Amanda Treharne - 9710 0462
File Ref: DN17/0008

**Proposal: Modification to the Concept Plan and Project Approval for
Woolooware Bay Town Centre
(MP 10_0229 MOD 2 & MP 10_0230 MOD 6)
Property: 455 Captain Cook Drive, Woolooware**

Thank you for the opportunity to review the proponent's Response to Submissions dated 10 October 2017.

Figure 2- Amendments to exhibited building heights and indicative envelopes

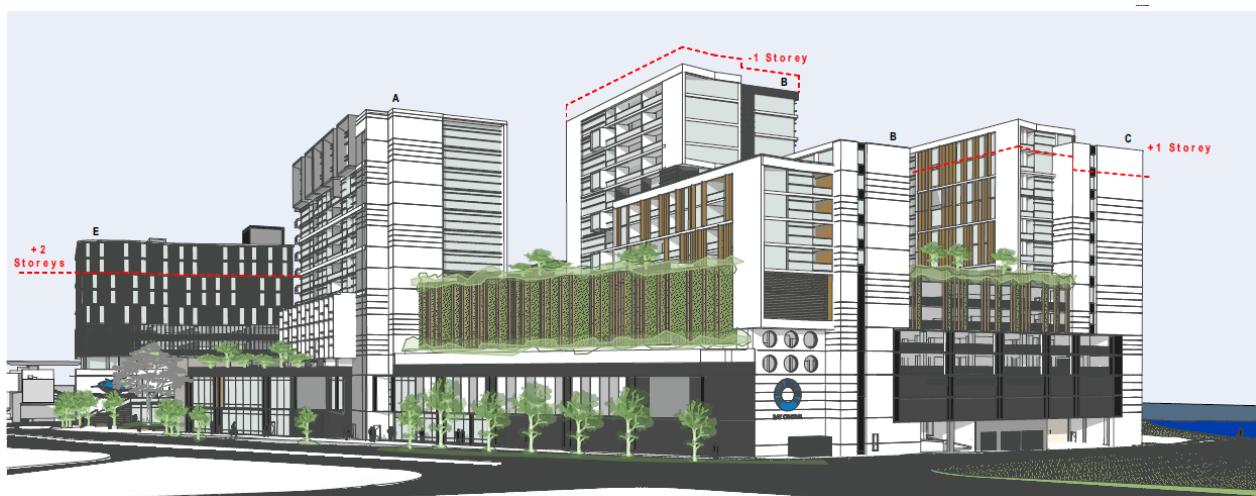
Removal of the height from Building B is a positive step, though transferring this built form on to Building C serves to reduce the difference and modulation between the towers and solidifies the mass overall. The additional height adds to overshadowing of units in Building B and blocks views from units that would previously have benefitted from an open outlook. Overall this change does not address Council's concern regarding the bulk and scale of the proposed development.
